R/17/26/CLP

Subject: FW: Urgent: Retrospective Planning Application and Enforcement Delay – 31 Windmill Drive, Rustington

Having now reviewed the submission in full, it is clear that the applicant's description is not accurate. Aside from the other matters already raised, this is **not a dormer window**, but a **full-width first-floor addition to a bungalow**, PLUS a **new side-facing window** overlooking our property.

**Proposed First Floor Plan**  
(Dimensions are for reference only. TBC on site)

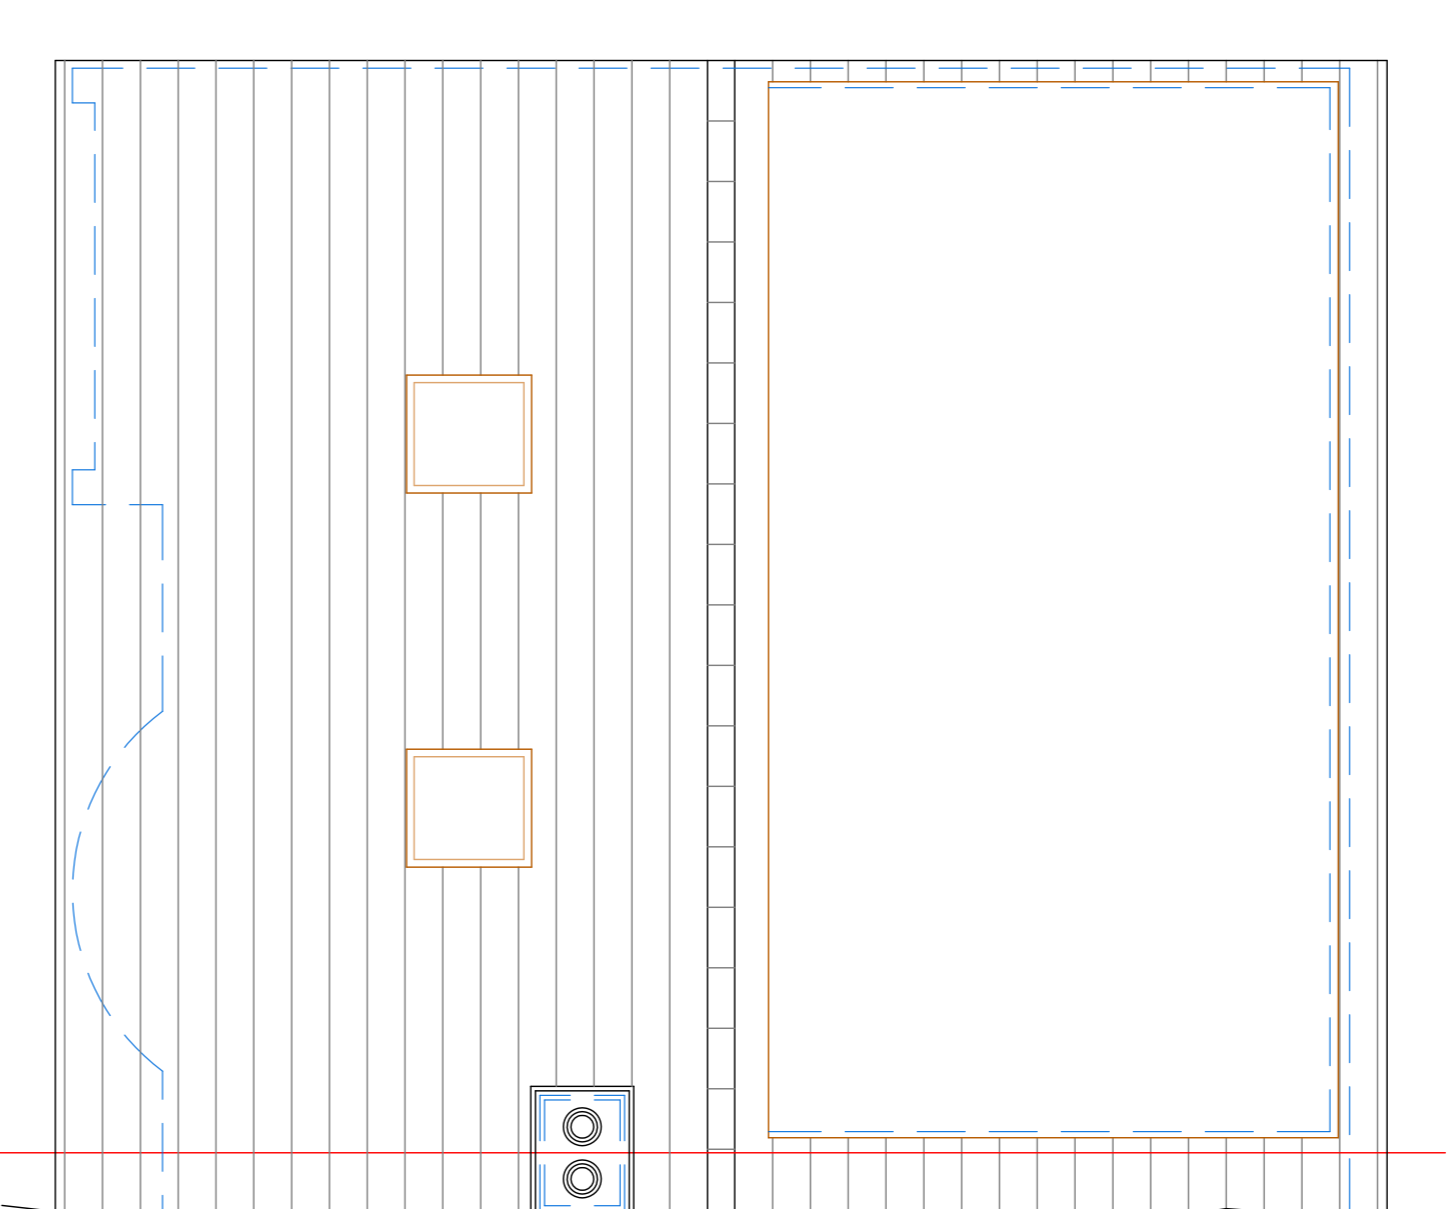
There is **no reference whatsoever in the application to the side-facing upper-floor window**, despite the fact that this window has been constructed and directly overlooks our second bedroom. This omission is not a matter of interpretation or judgement – it is an objective failure to describe what has actually been built.

**Proposed Rear - North East Elevation**  
(Dimensions are for reference only. TBC on site)

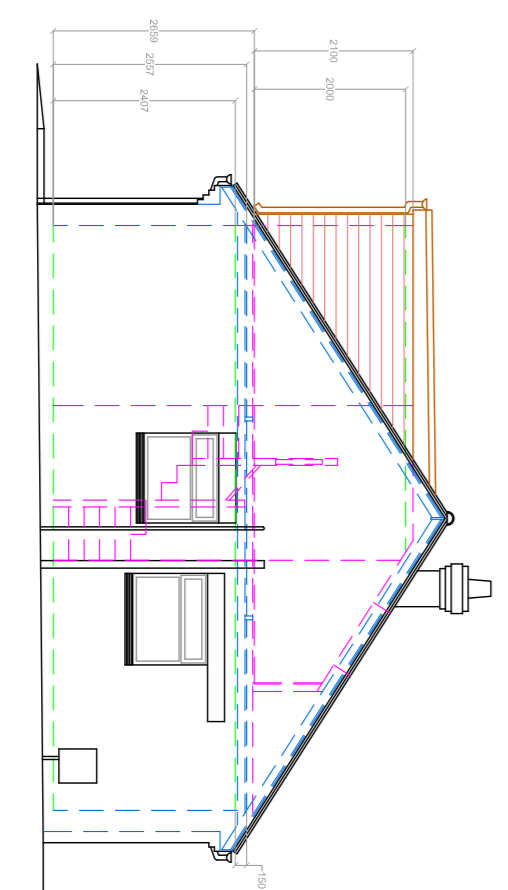
The overlooking and loss of privacy cannot be properly understood from drawings alone. From our garden - previously private and our principal evening space - the double rear windows and massing of what has been built are imposing and intrusive.

What has been constructed at 31 Windmill Drive is not a dormer by any reasonable or technical definition. It is a full-width, first-floor extension across the entire footprint of the bungalow, with large areas of glazing. It does not project from the slope of the existing roof, it is not subordinate to it, and it materially alters the scale, massing and character of the original dwelling. The attached photographs clearly show this.
